Planning - Case Comments

Project Number: PR-2025-020159

Project Name: 2210 New York Ave. SW

Request: Sketch Plat – To create two lots from four existing lots

PLAT OF  
LOTS 8-A AND 10-A, BLOCK 2  
WESTPARK

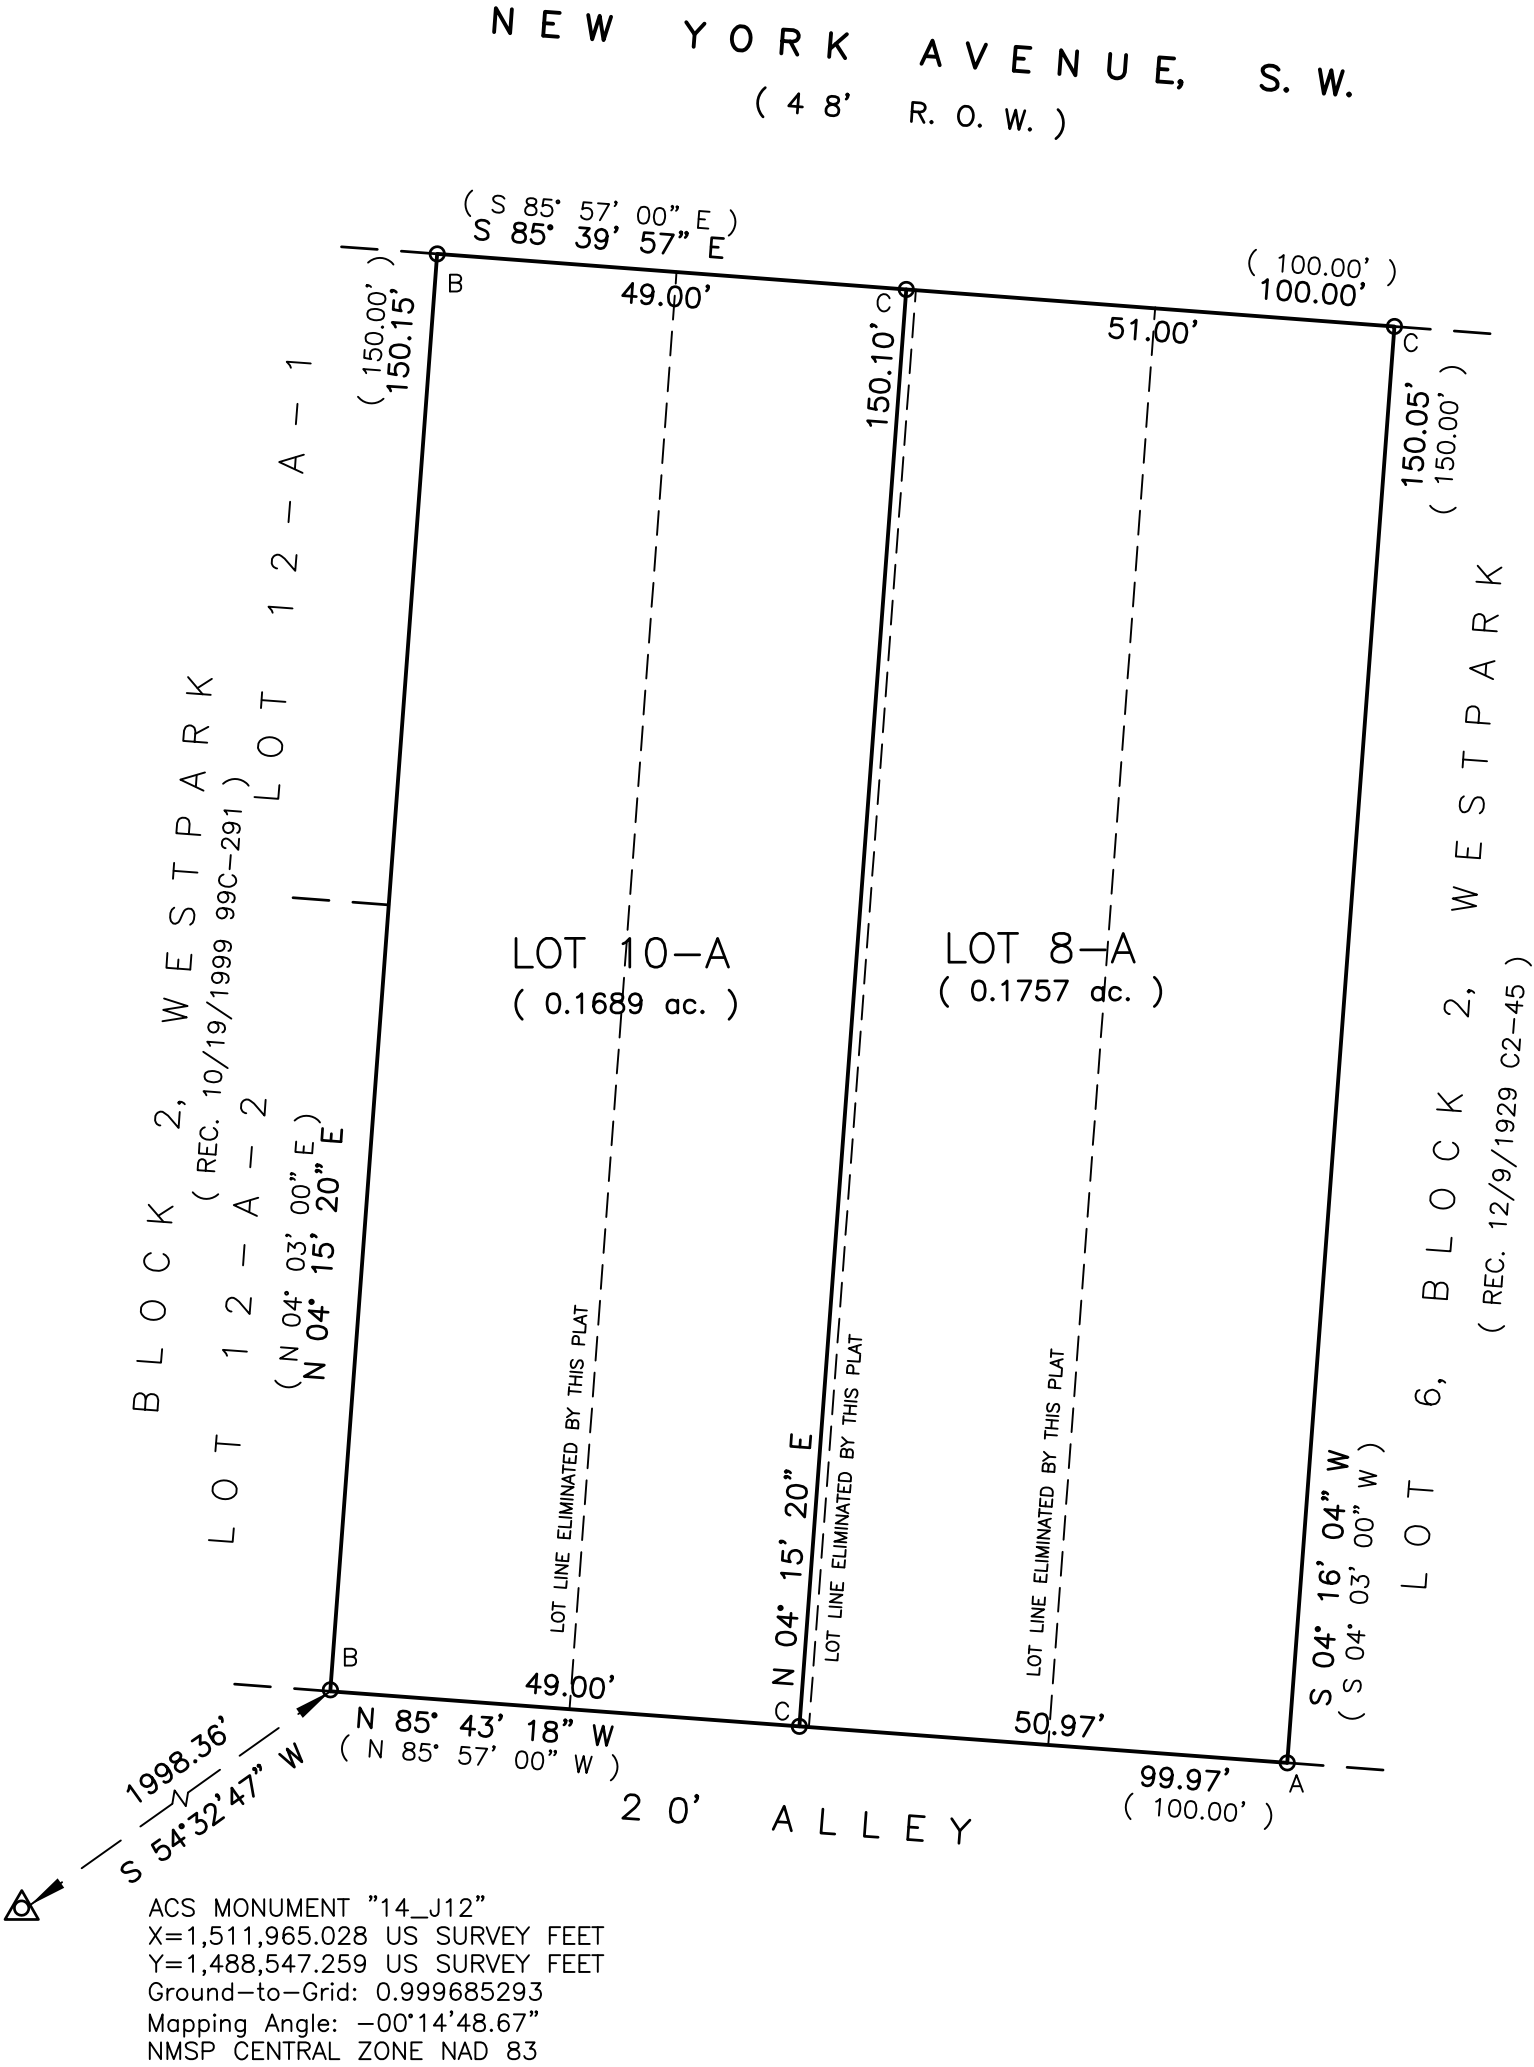
- Demonstrate compliance with Section 7 of the DPM, Table 7.2.29, regarding Sidewalk width requirements and its landscape buffer. New York Avenue SW is a local street and requires a 5' sidewalk with 4' to 6' landscape buffer. Planning staff defer to Transportation team to determine whether a determination letter is necessary to meet these requirements.

*This subdivision appears to meet the Contextual Lot size standards, with an **average lot size of 0.1658-acres**. The **newly created lots are 0.1757 and 0.1689 acres**, which fall within the required range-between the smallest lot (**0.1243 acres**) and largest lot (**0.2072 acres**).*
